Addendum 01

To: All Select Bidding General Contractors and Registered Plan Holders
From: Ben Walter, CWS Architects
Regarding: **Logan Place SRO Apartment – Bidding Documents**
Subject: **Addendum 01**

The following addendum items apply to the project known as the **Logan Place** located in Portland, Maine.

Drawing Number:  
**A5.2**

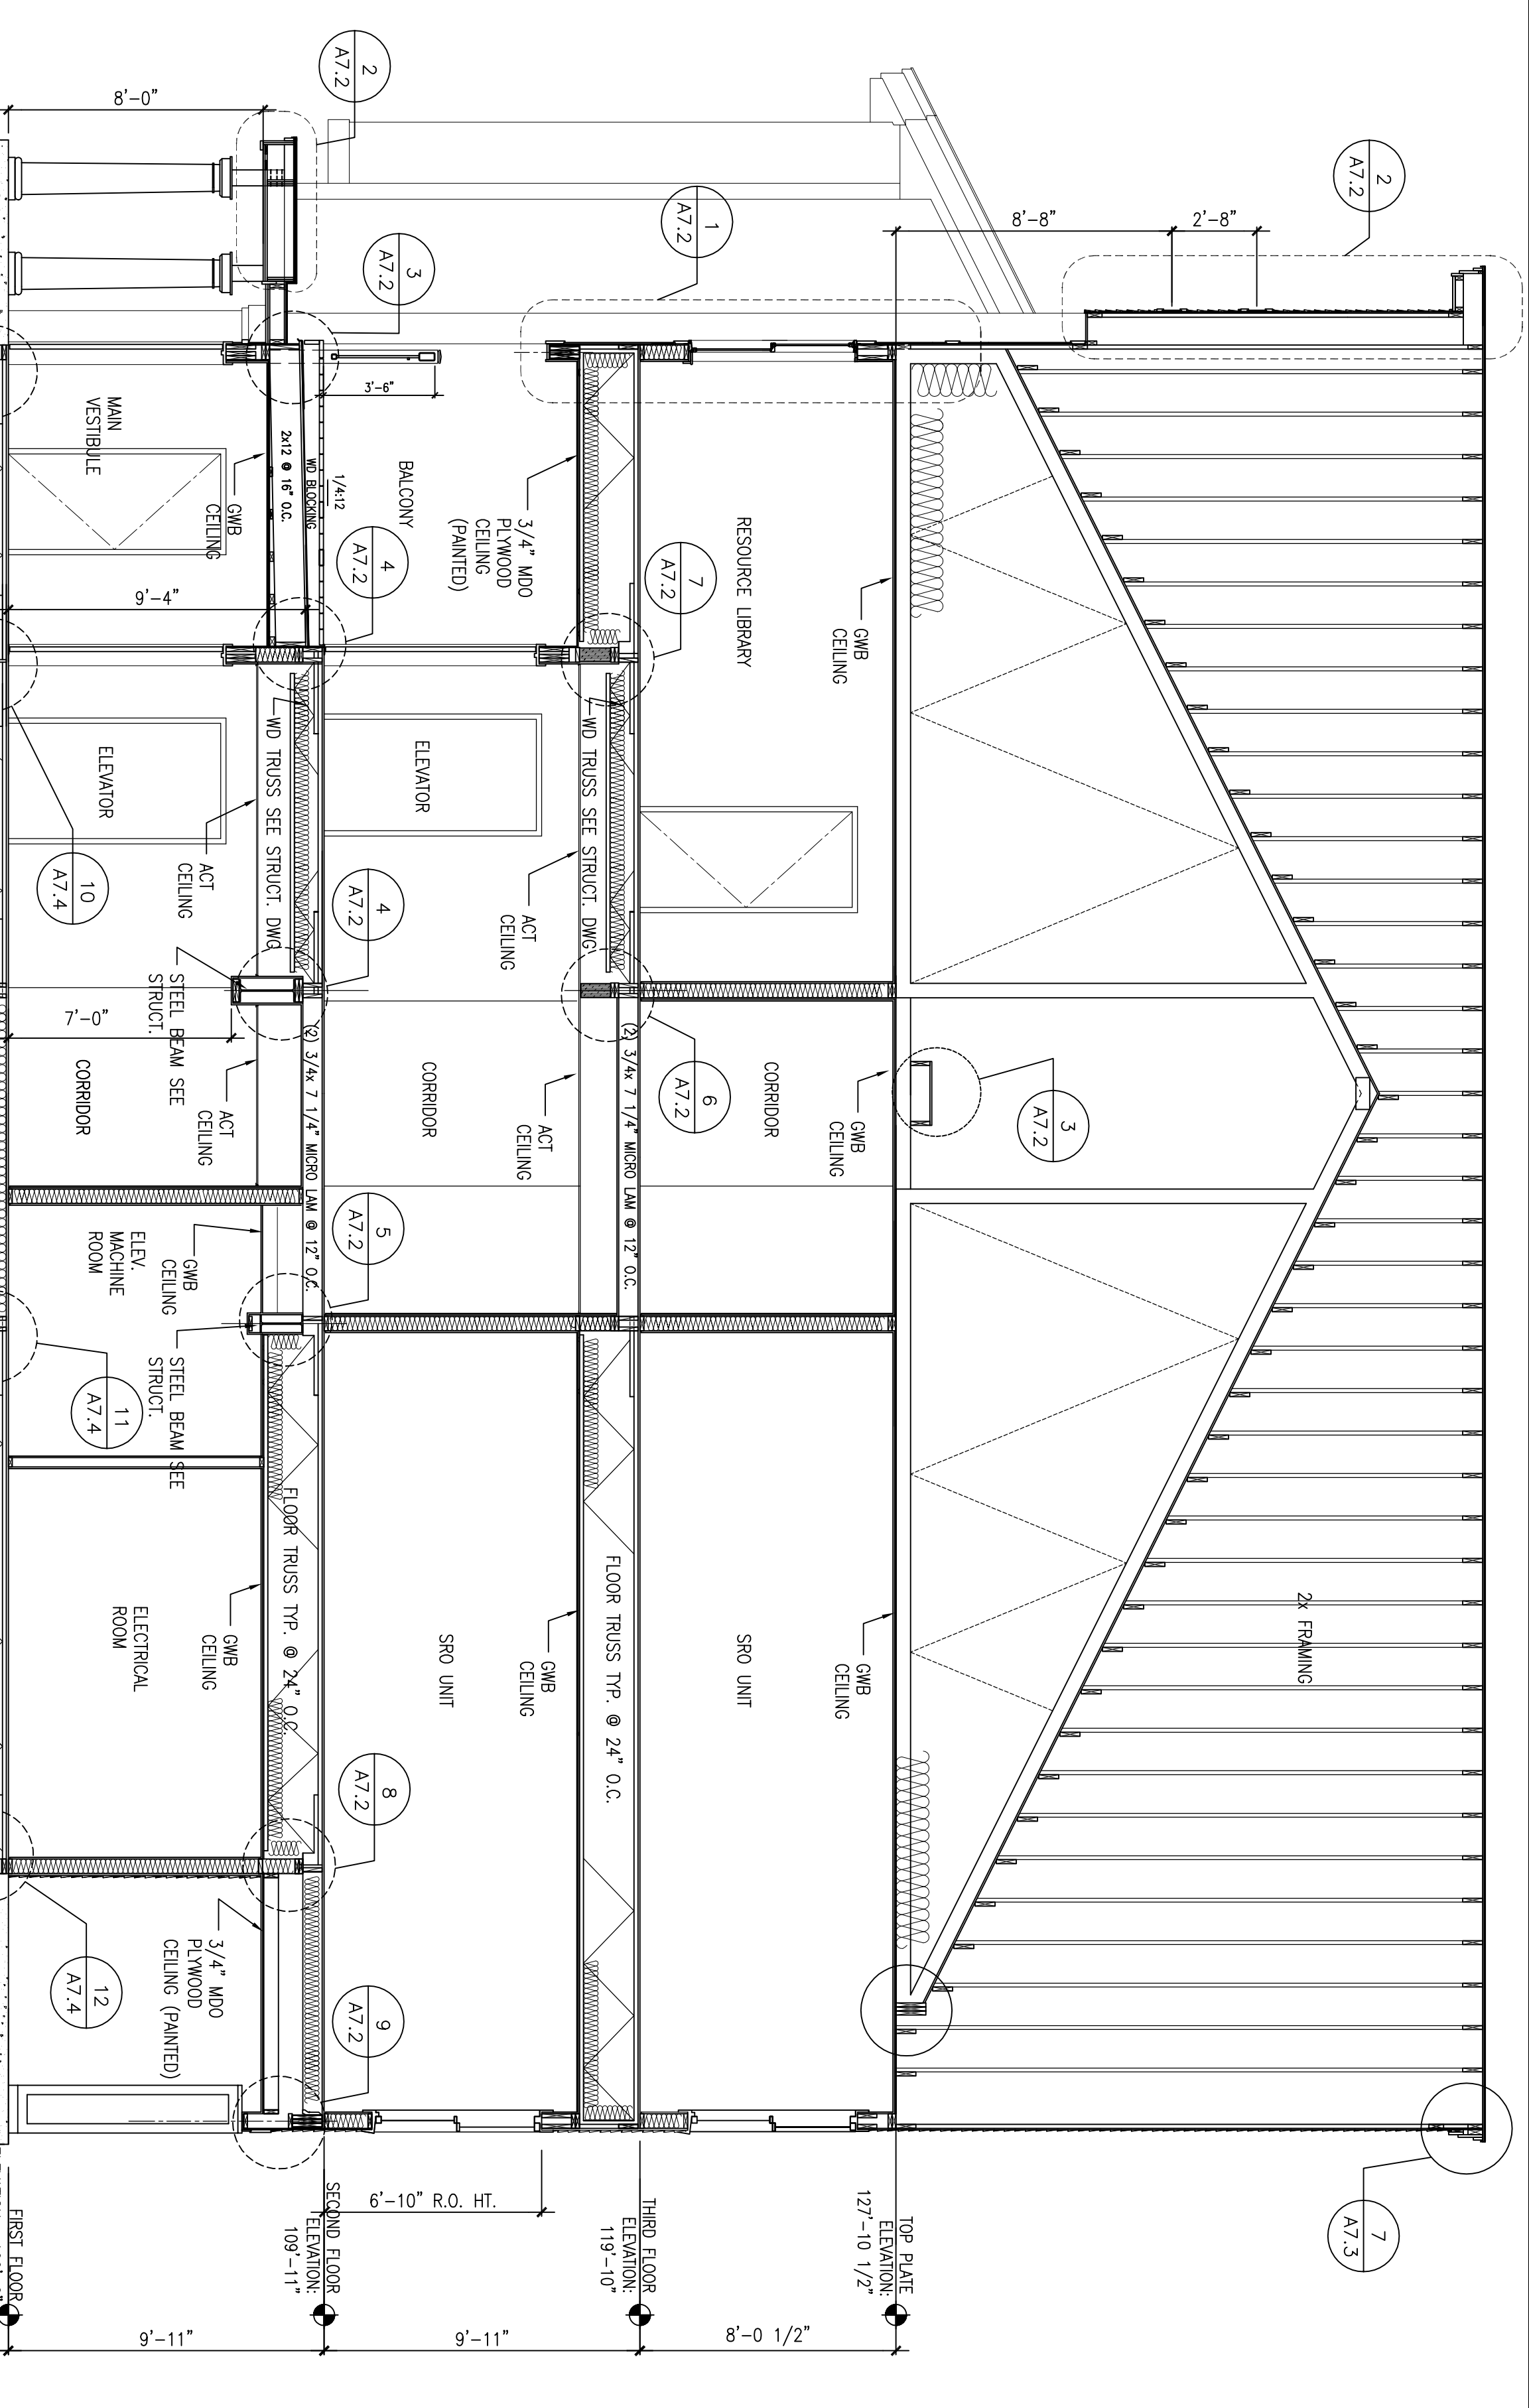
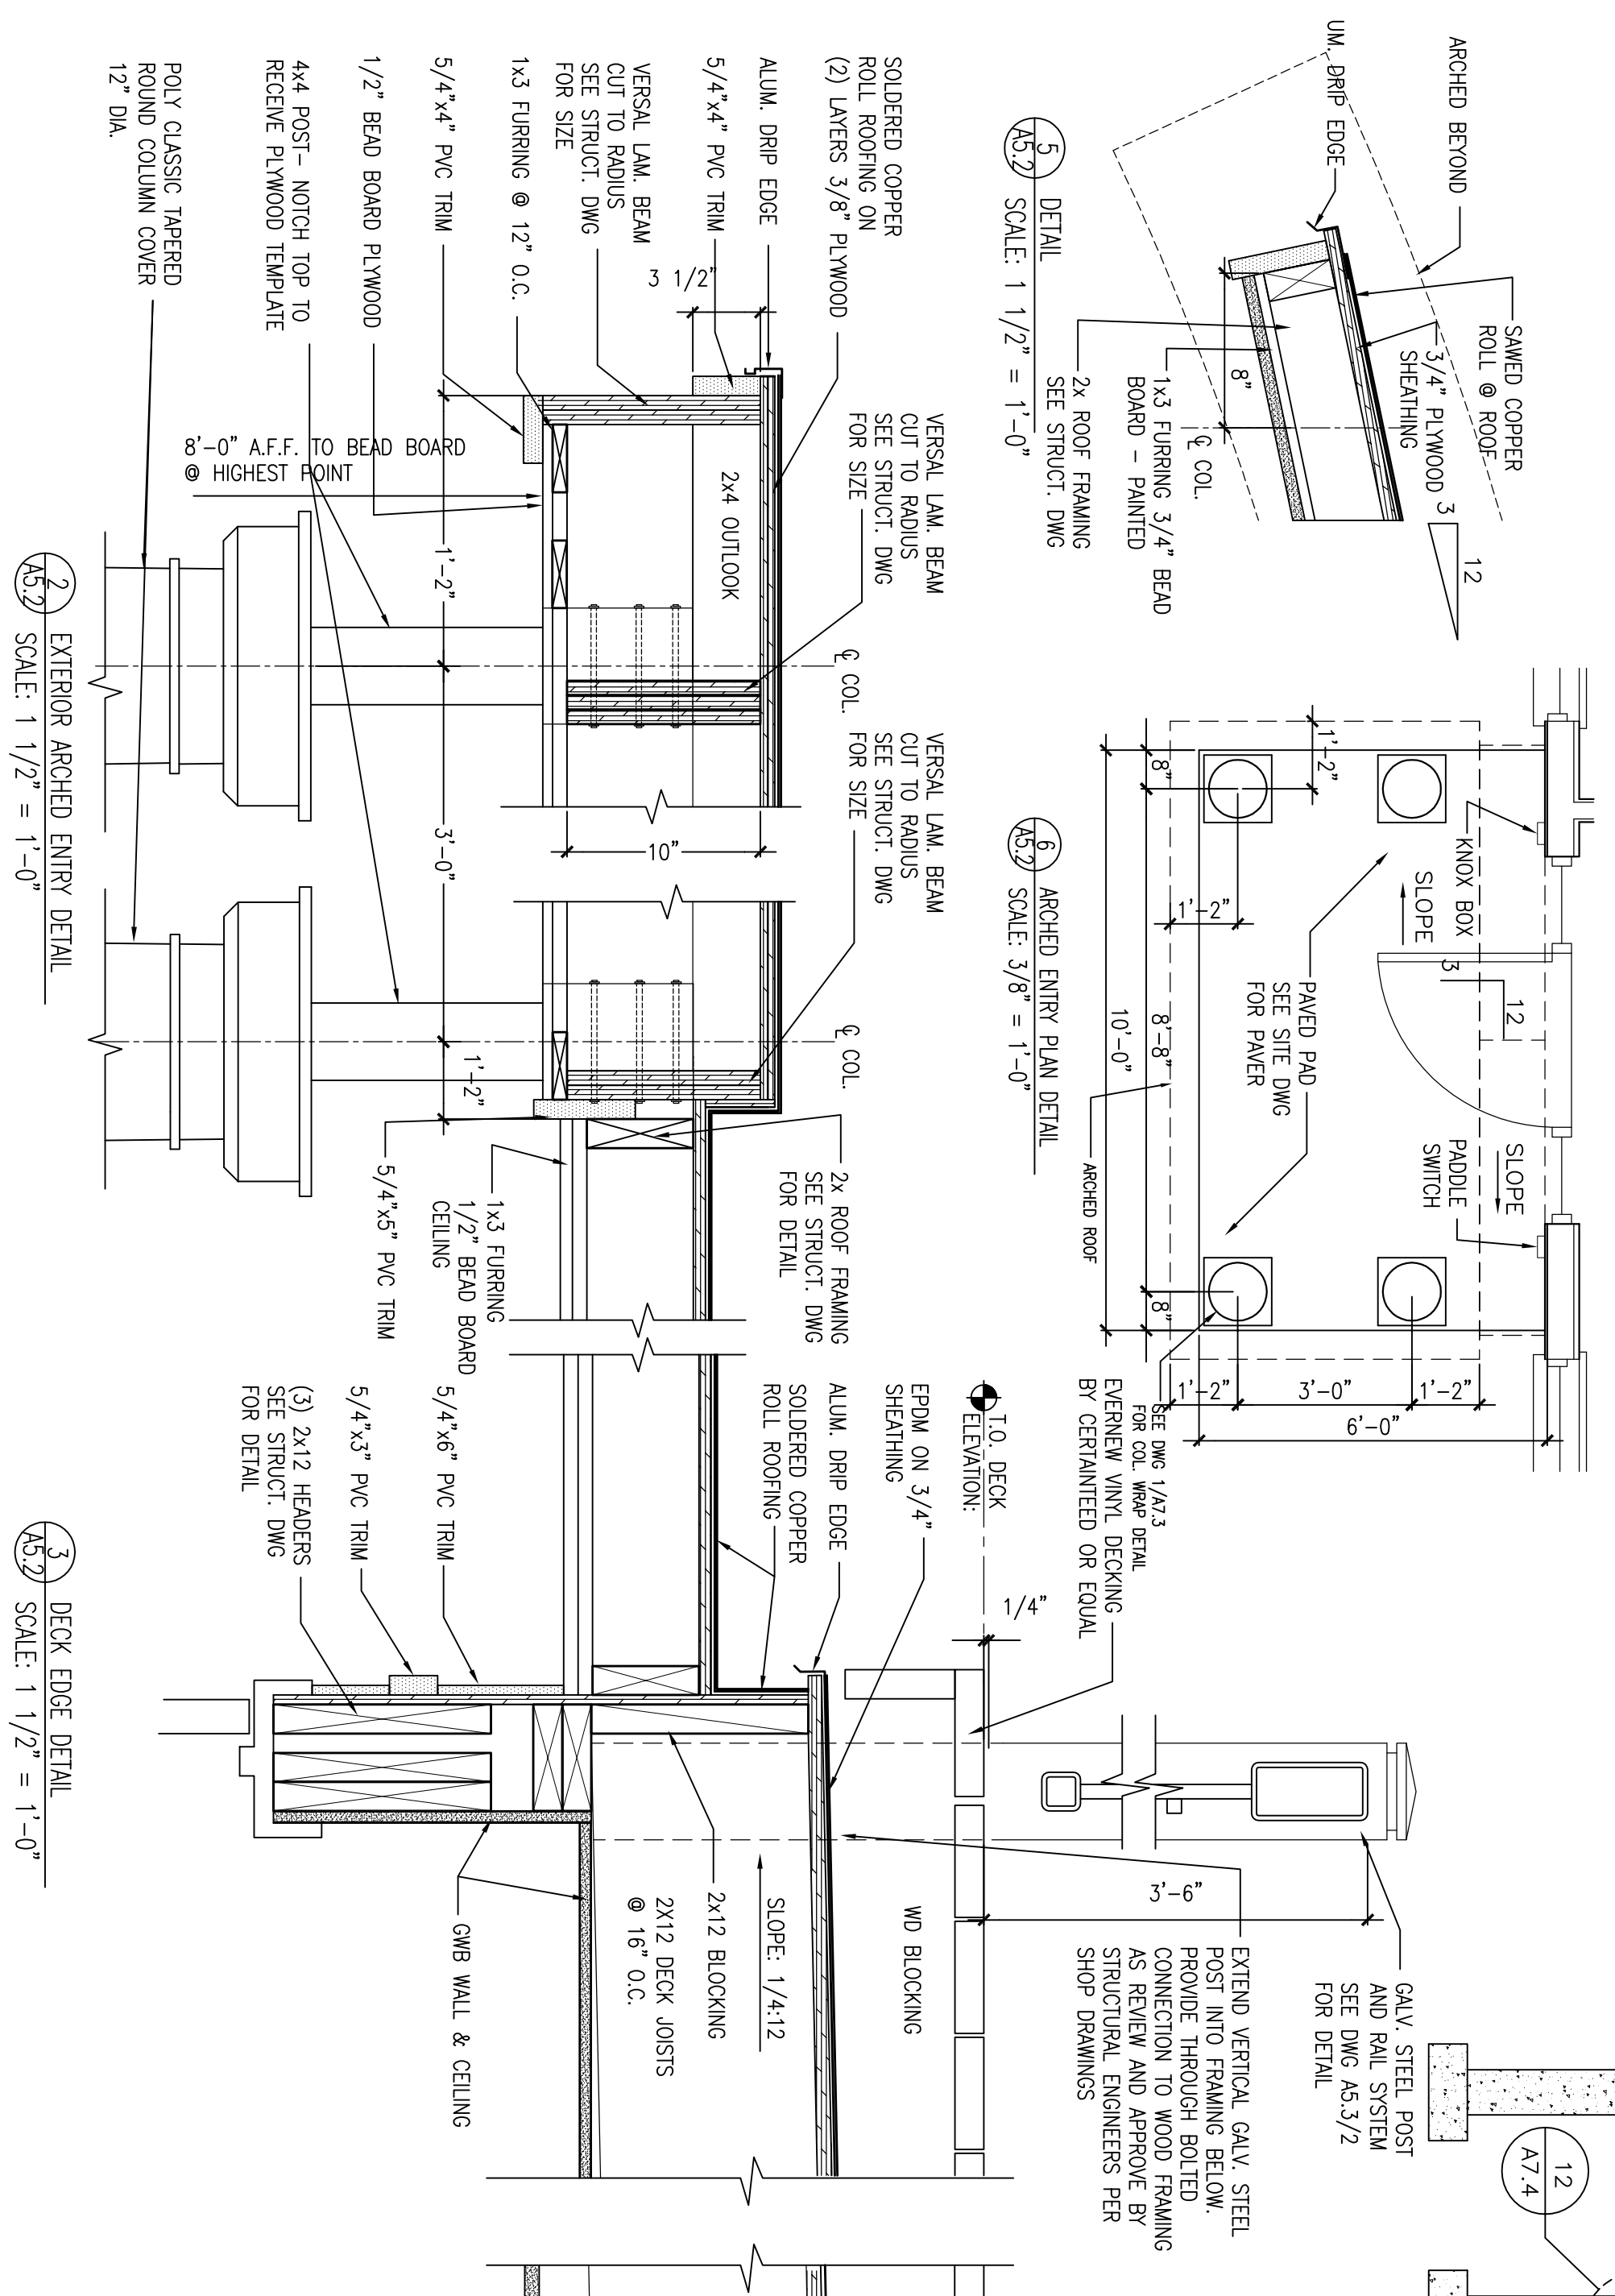
18. Modify all drawings Title Border: Change YC Portland L.P. address to 307 Cumberland Ave. Portland, Maine 04101.
 19. Clarification: Provide Poly-Classic Tapered Round – Plain Fiberglass columns by Brosco or equal at exterior locations where indicated. Refer to drawing A5.2 for columns size.
